From: Richard Castro-Parker <Richard.Castro-Parker@arun.gov.uk>
Sent: 16 December 2019 18:11
To: Planning.Responses <Planning.Responses@arun.gov.uk>
Cc: Juan Baeza <Juan.Baeza@arun.gov.uk>
Subject: FW: A/157/19/PL - Pedestrian Link - Quiet Waters to CALA homes site

The plan shows the inclusion of a footpath to complete the footpath link between the Quiet Waters and CALA Homes developments. The principle of the footpath is accepted providing that the following have been taken in to account:

A/157/19/PL - Pedestrian Link - Quiet Waters to CALA homes site

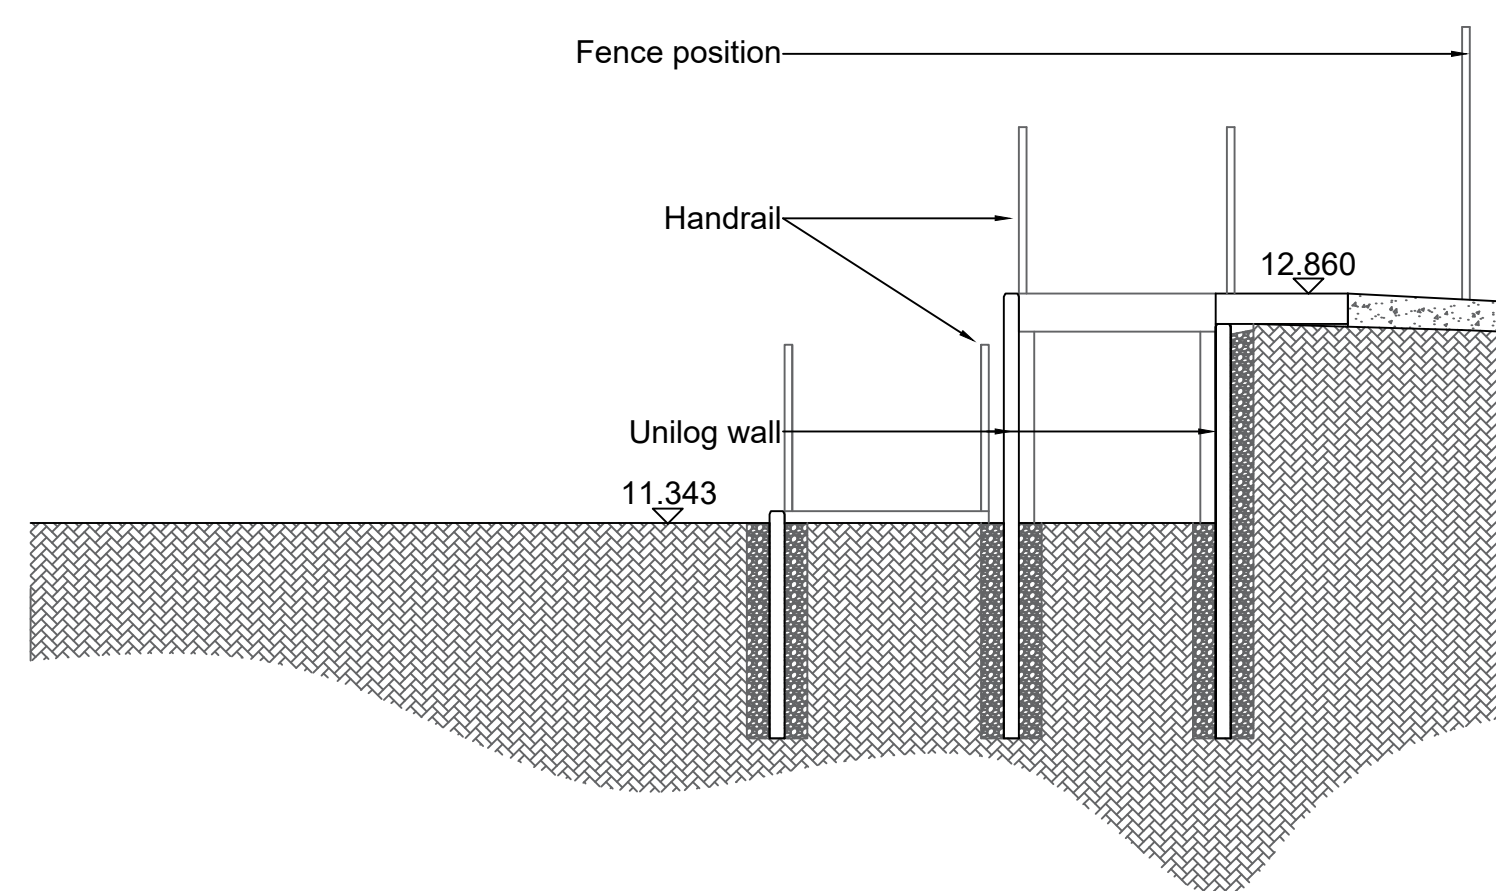
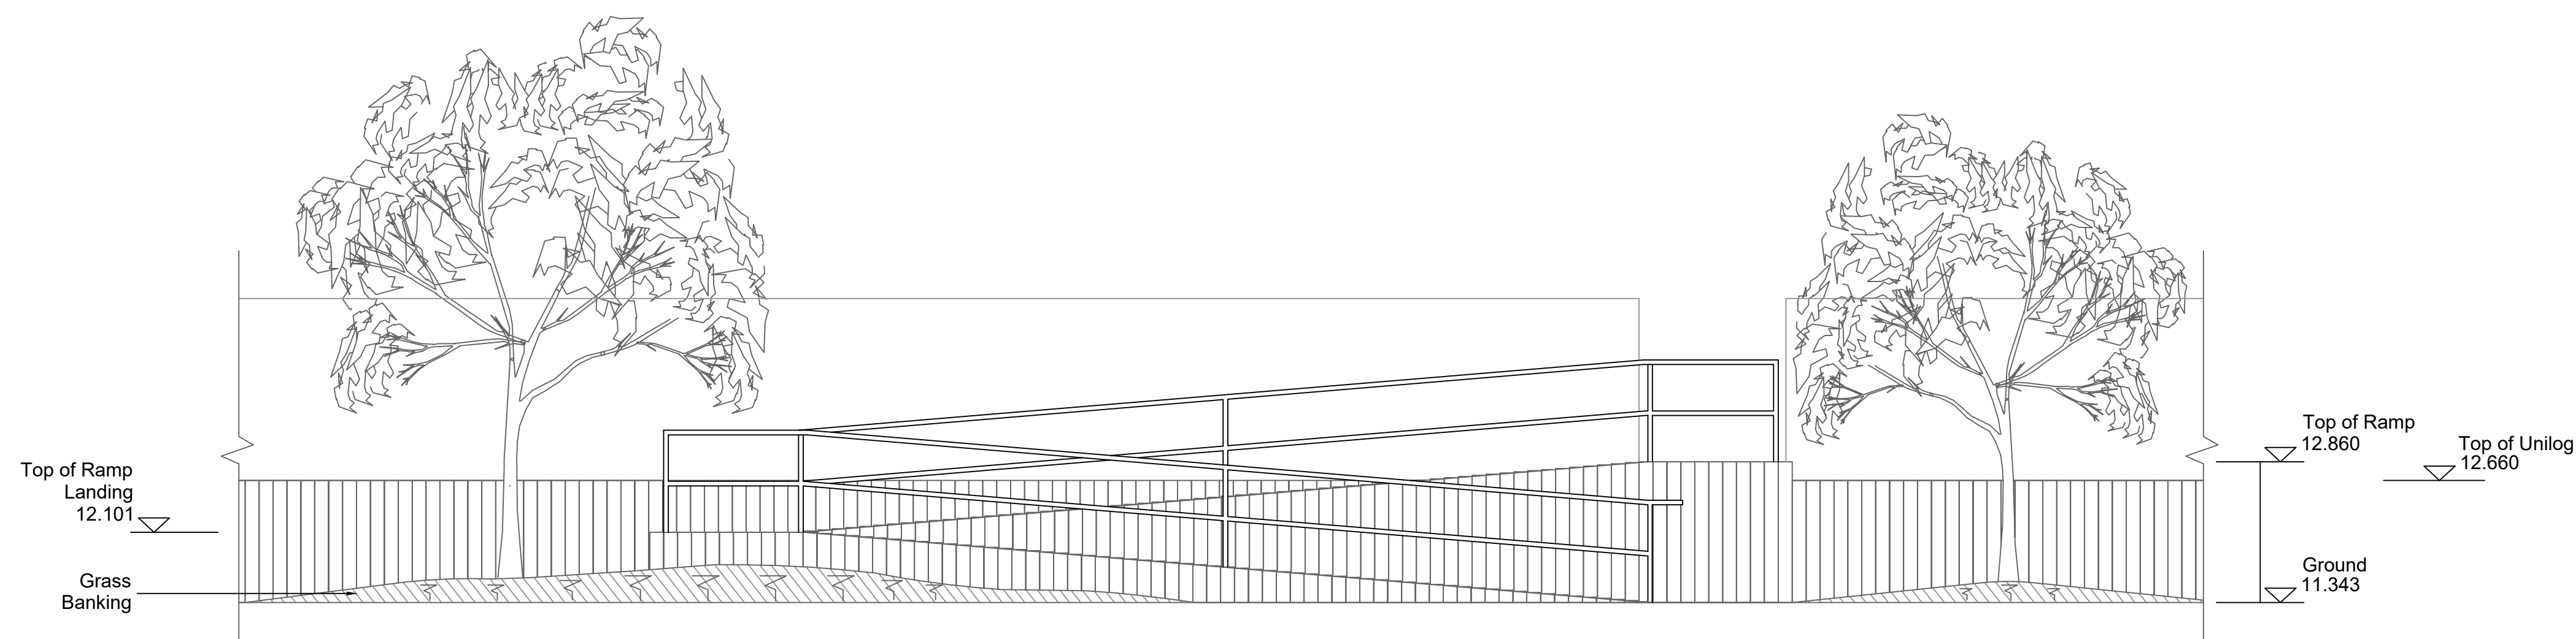
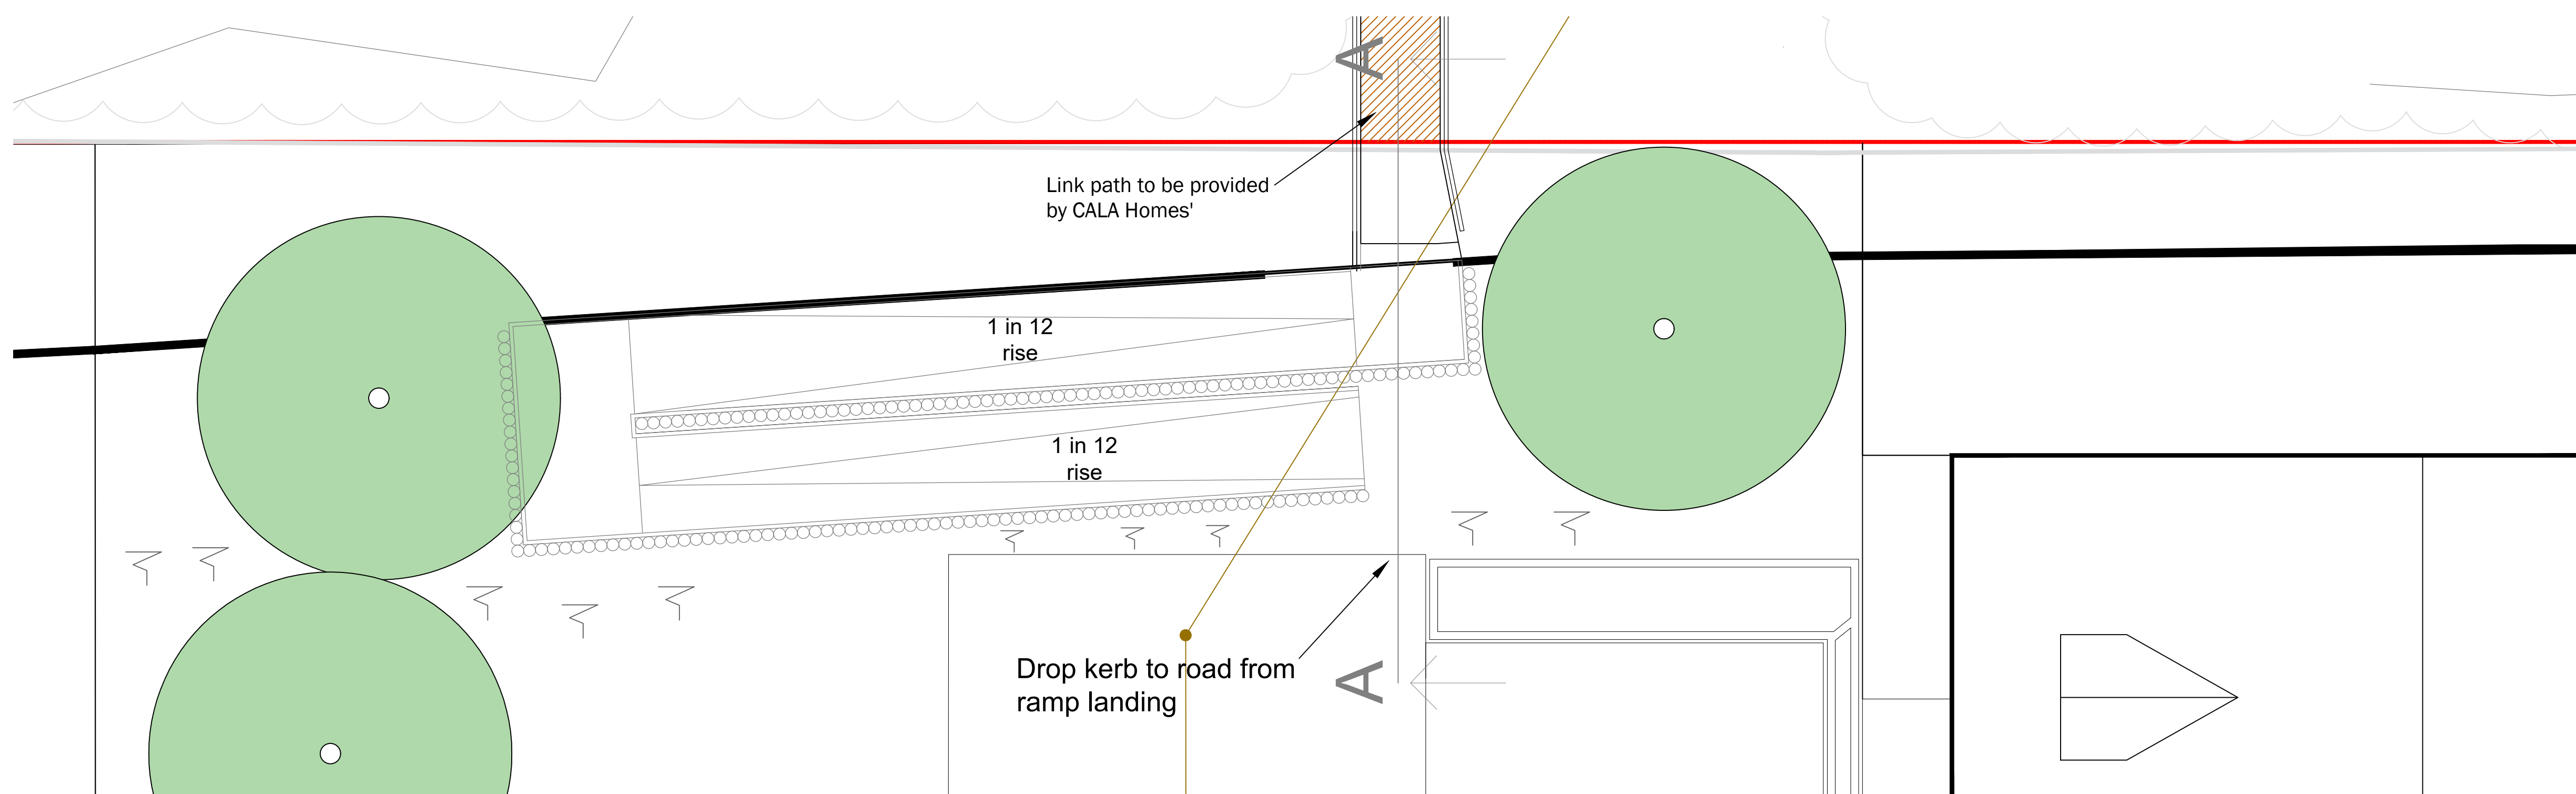
- The location and angle of approach of the footpath at the boundary is in accordance with the requirements of the Quiet Waters site. A plan needs to be provided showing the path on both sides of the boundary to confirm this.
- The levels of the path to be such that they aid the construction of the ramp on the Quiet Waters development and help minimise the difference in level between the two sites.
- The material of the path needs to match the proposed surfacing material of the link path on the Quiet Waters development. I did not observe other uses of the self-binding gravel on the CALA Homes site with footpaths nearby having a tarmac finish. The material should provide good accessibility and be low cost to maintain. Confirmation is required that the material is the same as proposed for the Quiet Waters site.
